MECKLENBURG COUNTY
Land Use and Environmental Services Agency

To: Michael Russell, Principal Planner City of Charlotte
From: Dylan Kirk, Sustainability Program Coordinator
Date: Wednesday, February 26, 2020
Subject: City of Charlotte October Rezoning Petitions 2020-002 through 2020-027

2020-014: The Villas on Erwin

**Villas on Erwin - Survey - RZ-3**

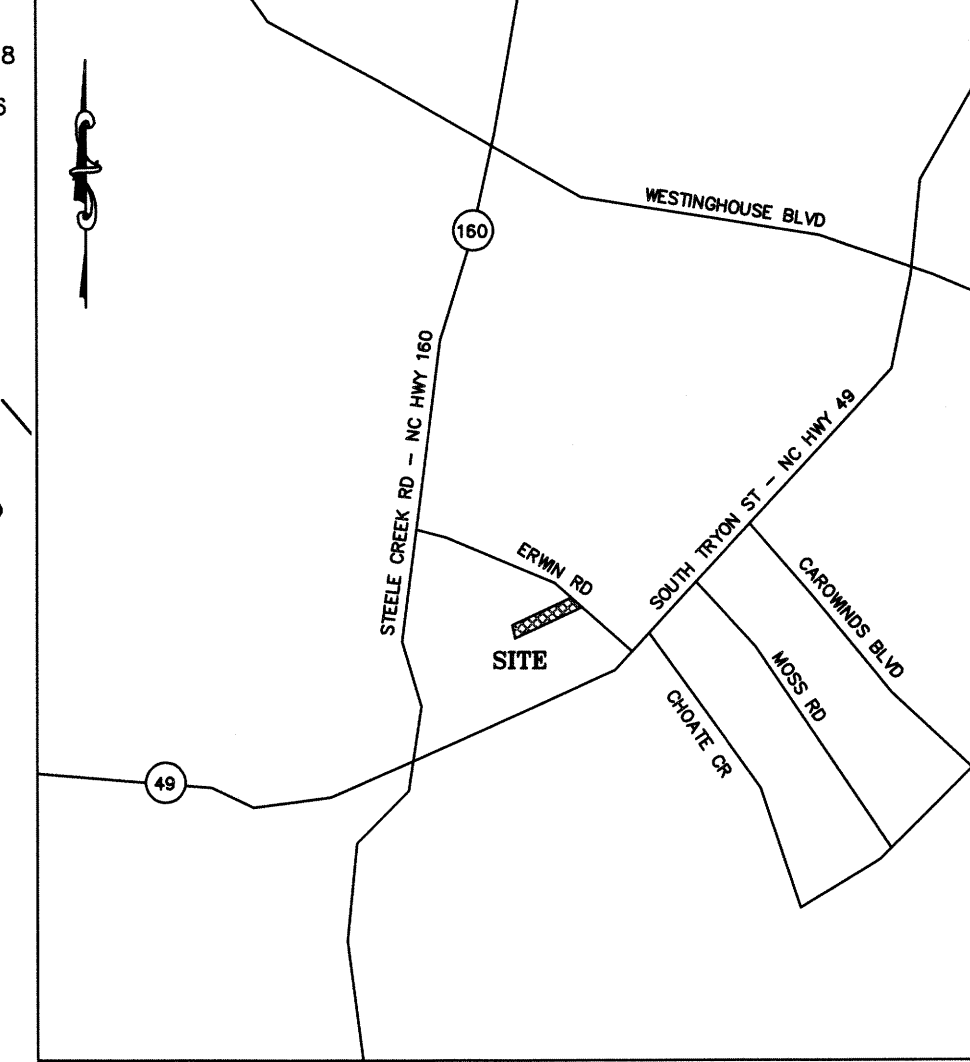
Ground Water Services Comments: Groundwater & Wastewater Services records indicate that a water supply well is located within the bounds of parcel 201-221-13. The water supply well should be protected during site development by flagging and fencing or be permanently abandoned in accordance with the Mecklenburg County Groundwater Well Regulations prior to site development commencing.
